**From:** Jeff Tarling  
**To:** Jean Fraser  
**CC:** Barbara Barhydt; David Margolis-Pineo  
**Date:** 11/4/2013 7:58 AM  
**Subject:** Re: 133 York St- PB Hearing Nov 12th confirmed

I have reviewed the latest landscape plan for the proposed 133 York Street project and offer the following comments & conditions:

**9 FREESTANDING SCREEN DETAILS**  
NOT TO SCALE

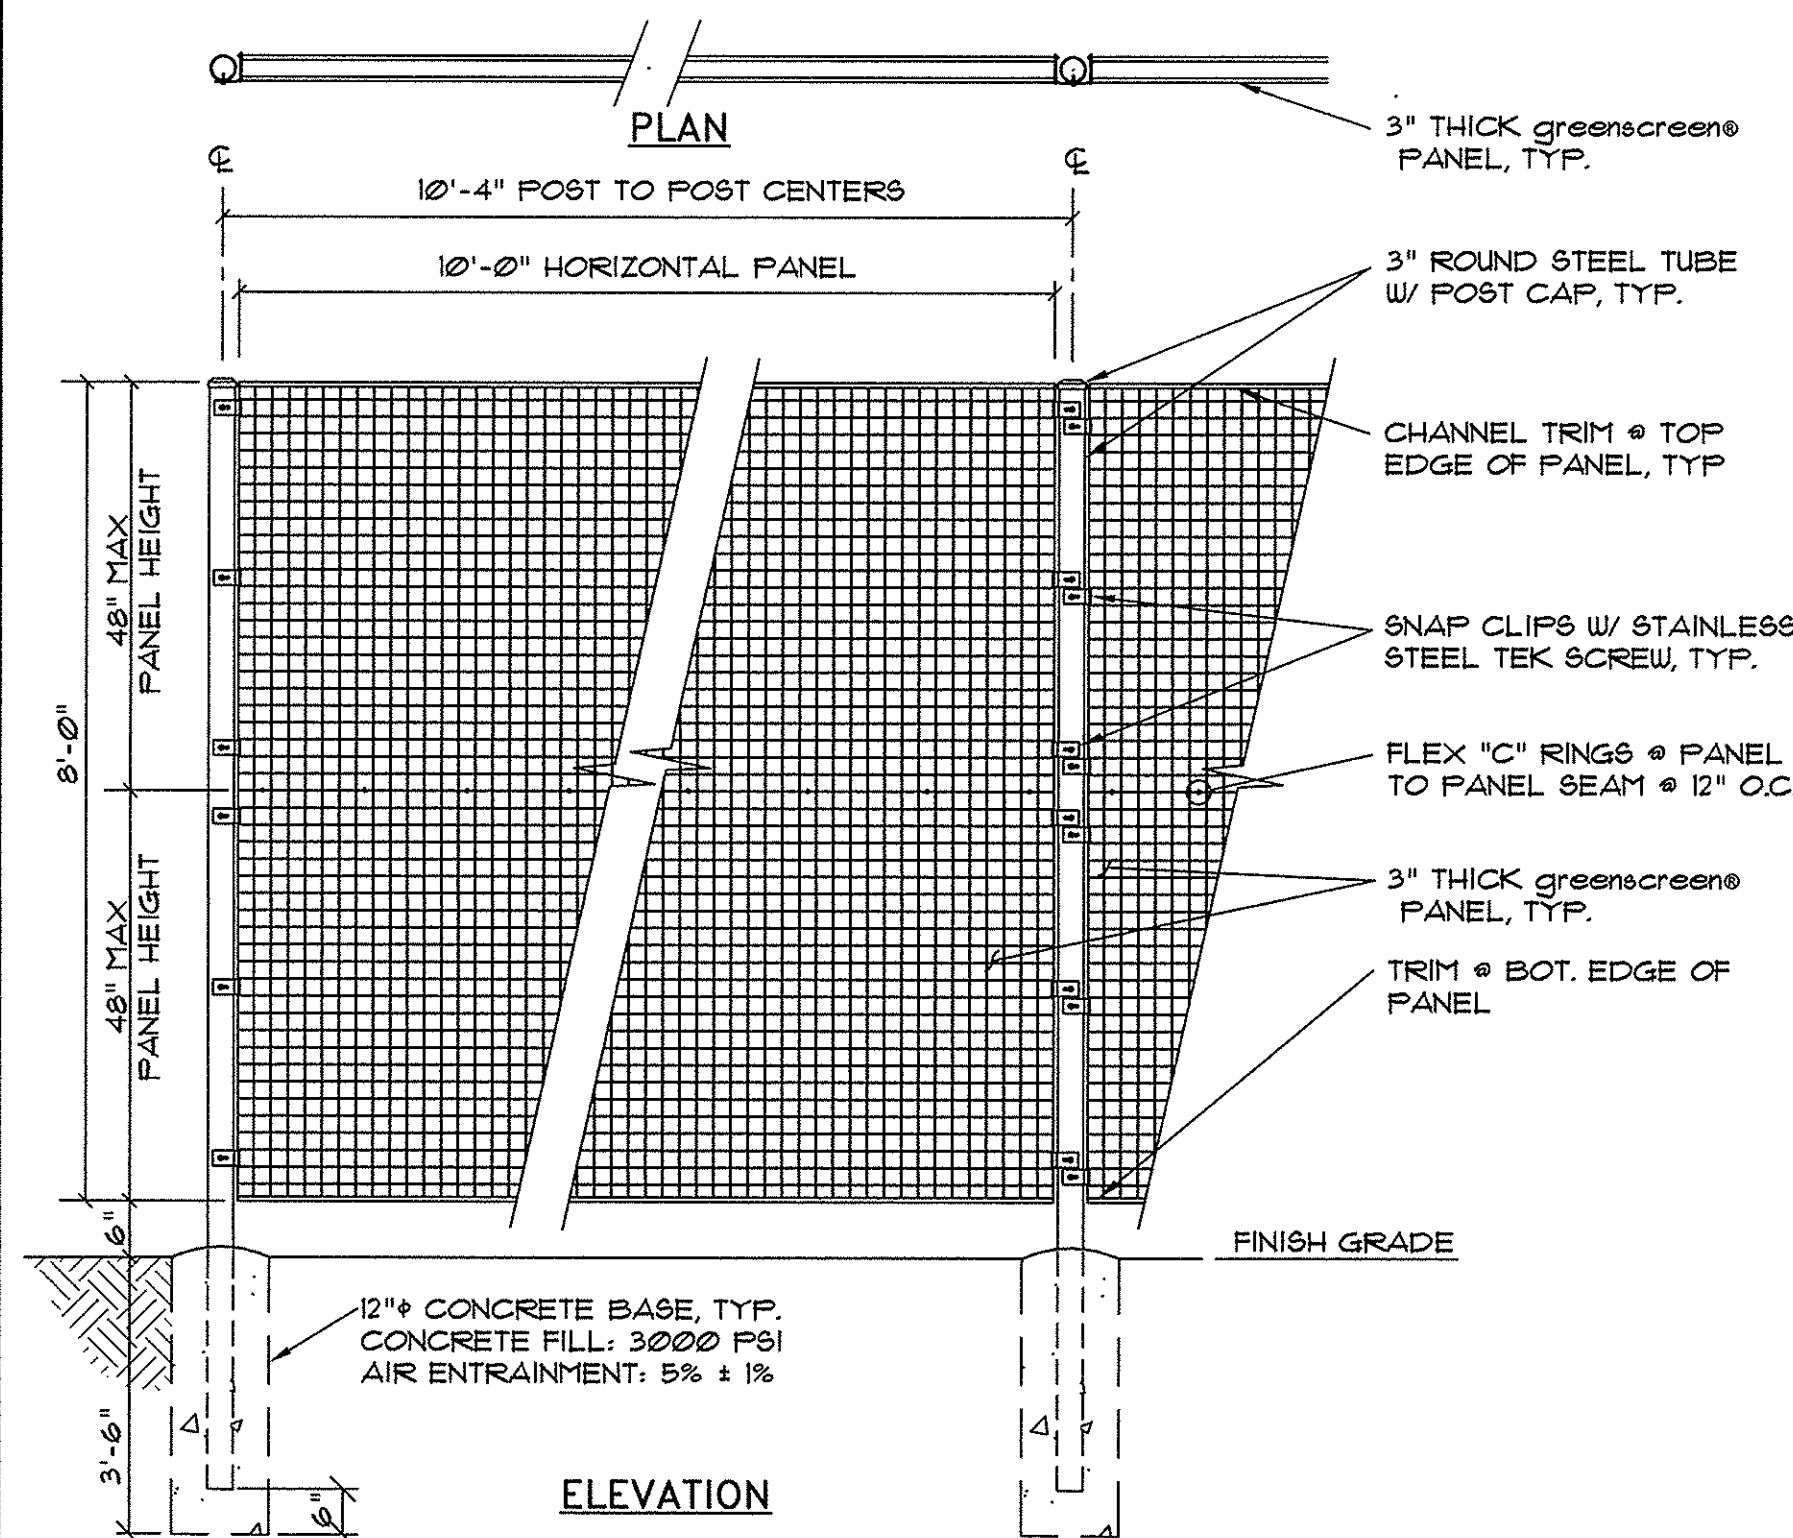
**c) Green wall -** the proposed project use of a green wall will help screen / buffer the adjacent building. The green wall plant type: Climbing Hydrangea is slow growing, and thus the proposed 1 gallon pot size much to small to be effective for many years... recommendations & condition the green wall plant sizes must be #3 pot & #5 pot sizes alternating minimum to provide a good start for the green wall.

PLANT LIST

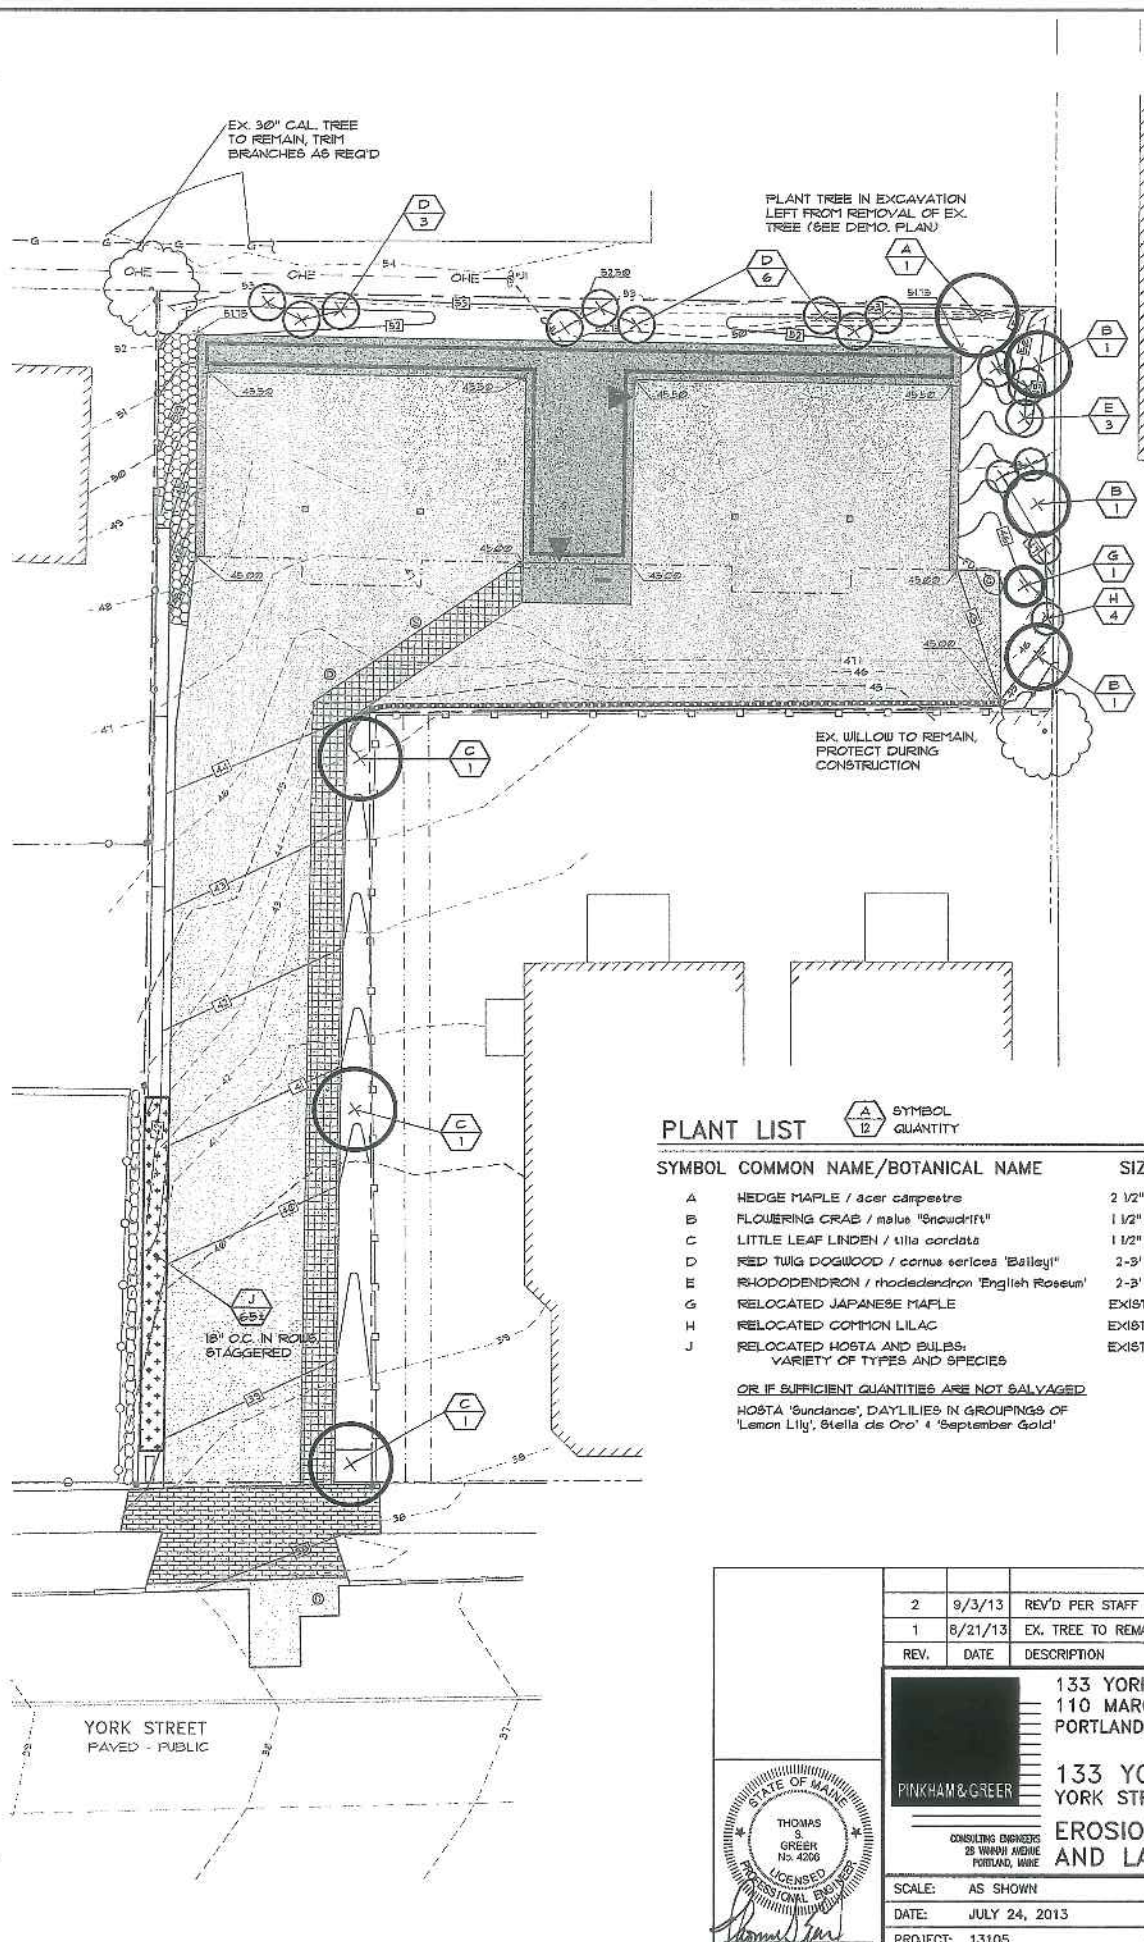
**b) landscape plant material: plant sizes - Condition)** shrub stock noted as "D" Clethra, "F" Deutzia, "J" Northern Bayberry, "K" Climbing Hydrangea, "L" Stephanandra shall all be #3 pot size minimum and tree sizes should be the following: "B" Flowering Crabapple 1.75-2" caliper, "C" Armstrong Red Maple 2" caliper. Items mentioned as "Existing", "G" Relocated Japanese Maple (#5 pot size), "H" Relocated Lilac (3-4'H) should also have these sizes as replacements if the relocation is not successful. (Too often good intent to save plants through construction are less then successful).
